29 October 2013

RMS Reference: SYD12/00883/02 Contact: Xi Lin
DP&I Reference: SSD_5397

**STATE SIGNIFICANT DEVELOPMENT – APPLICATION FOR THE REDEVELOPMENT OF THE
IMAX BUILDING – SSD 5397**

DRAWING TITLE  
 PROPOSED CLEARANCES TO RMS  
 ROADWAY STRUCTURES

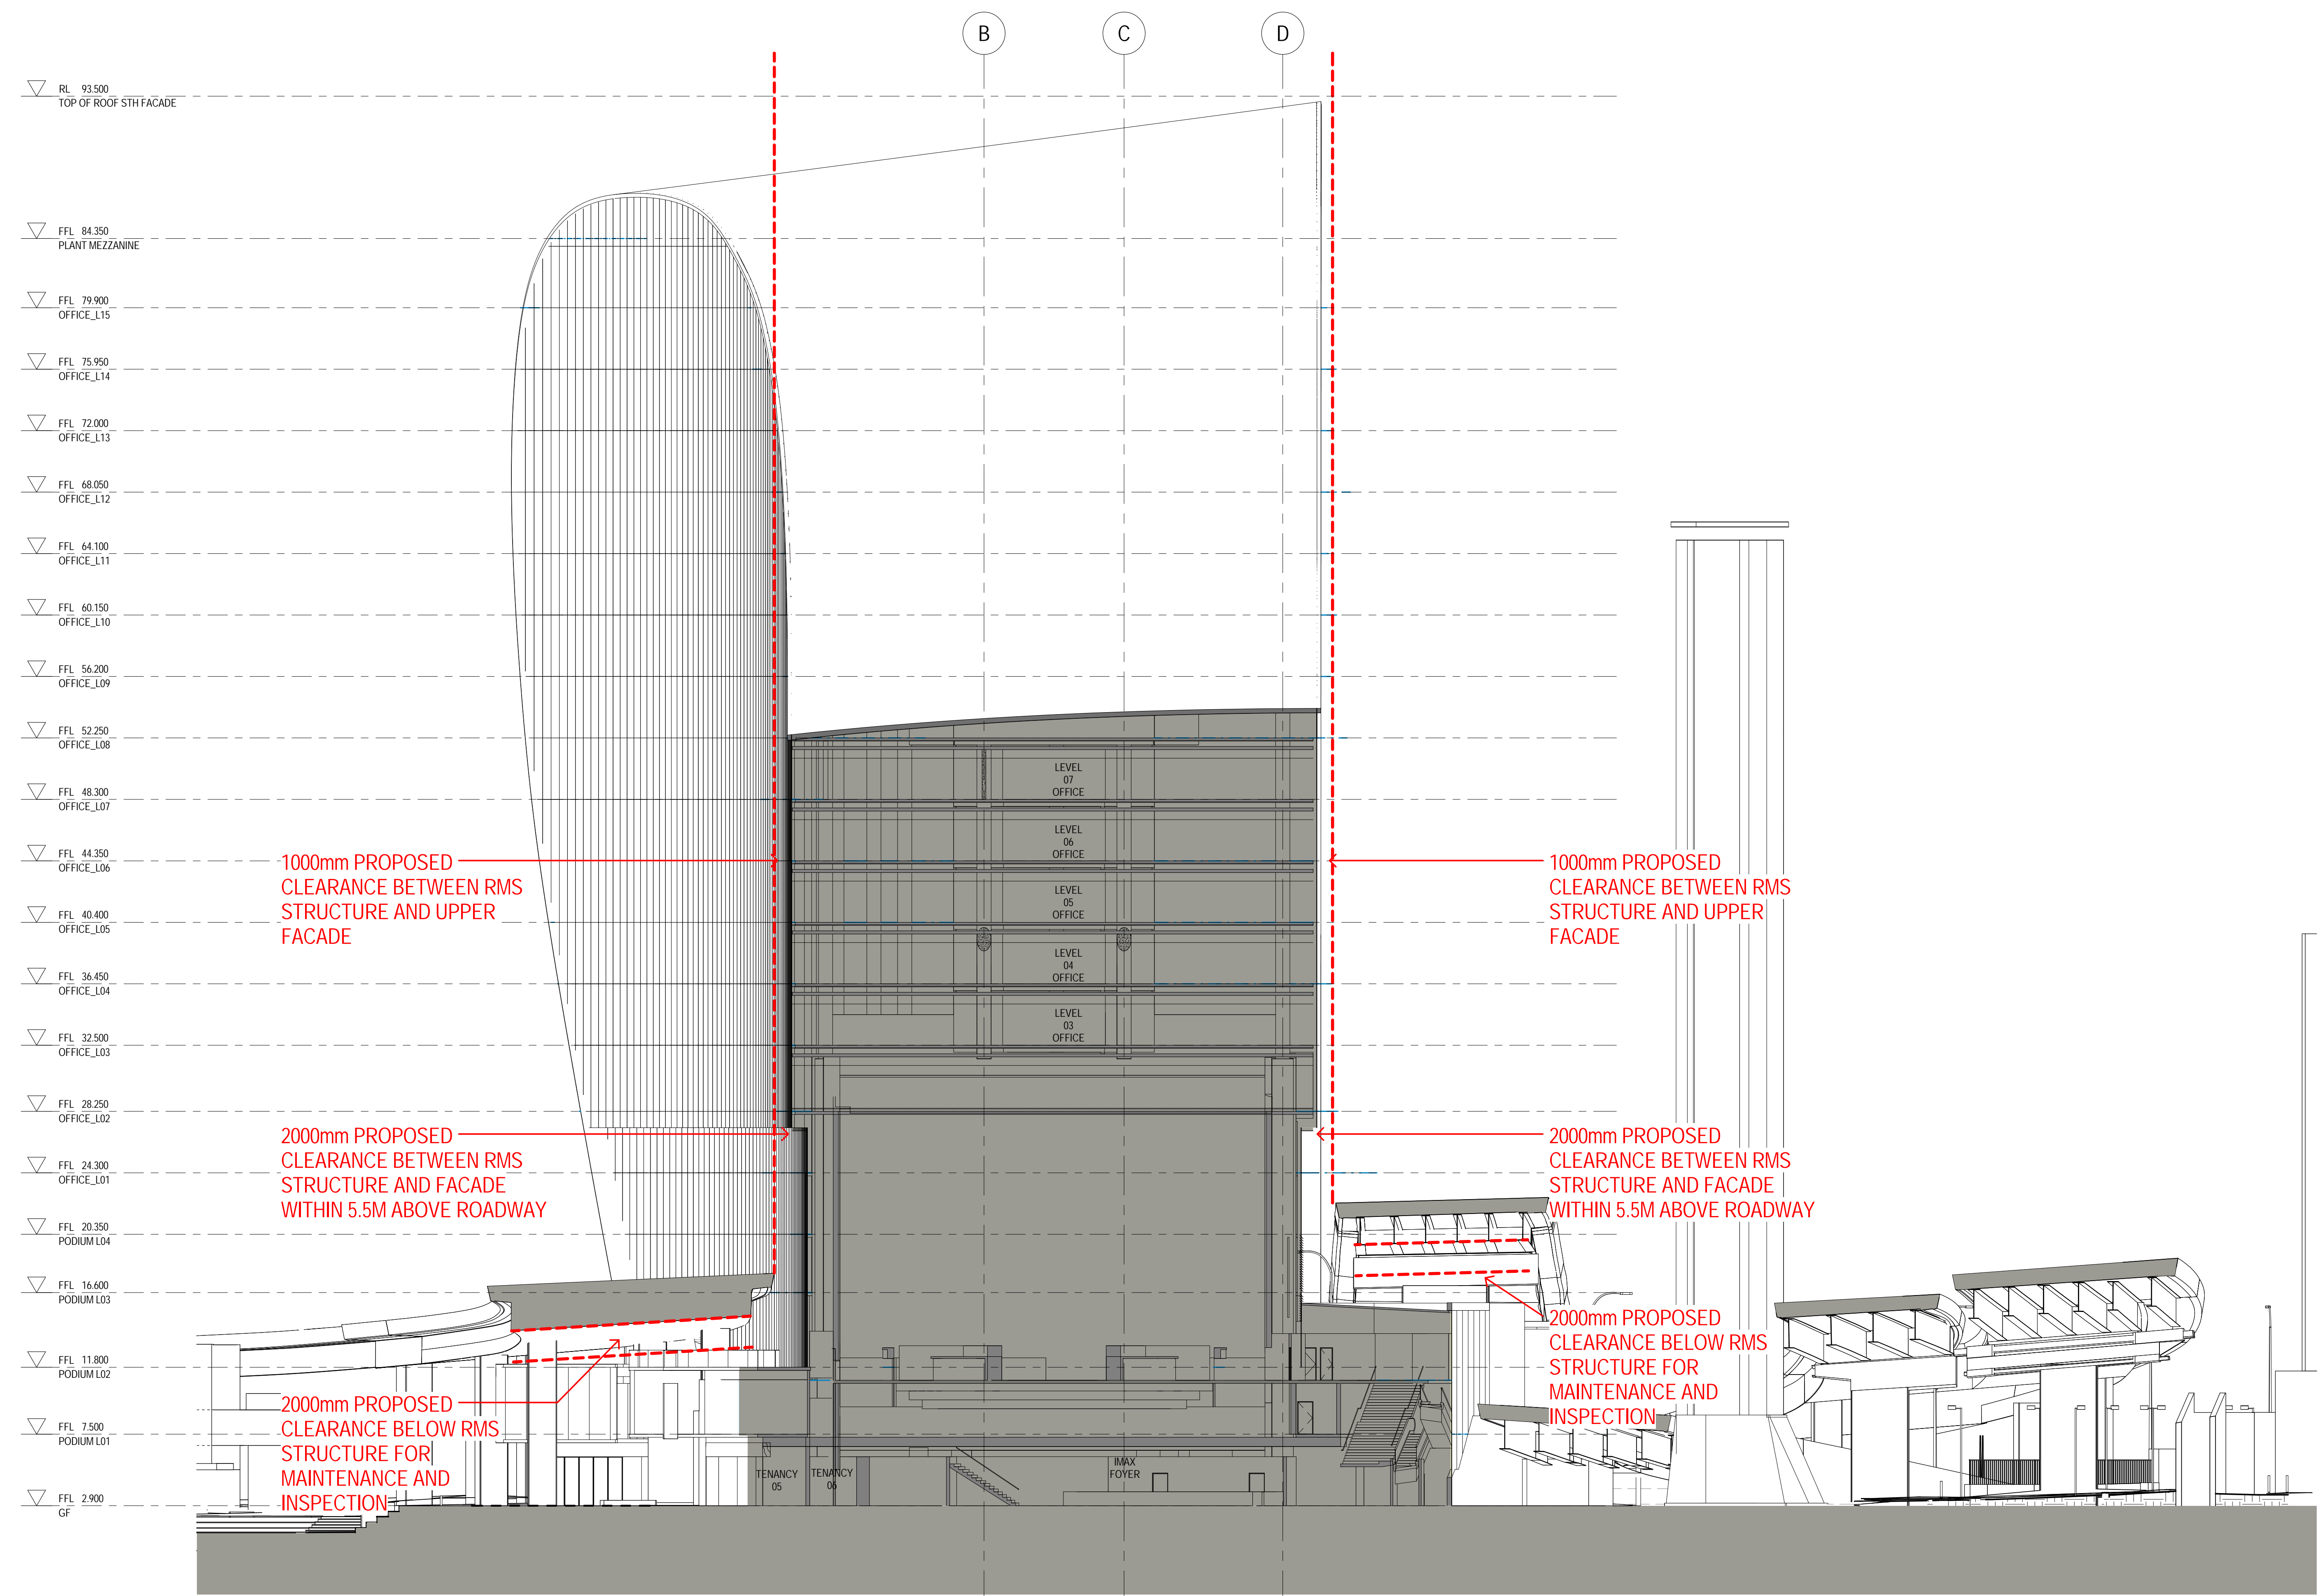
- a) No permanent infrastructure is to be constructed within two metres of the surface of any part of the Western Distributor structures. RMS Sydney Asset Manager is to be consulted at the preliminary and detailed design stages to ensure that the appropriate clearances from the Western Distributor structures are provided to allow for access for inspection and maintenance of those structures. (Note: This consultation would also address any exceptional circumstances where the two metre clearance cannot be provided).
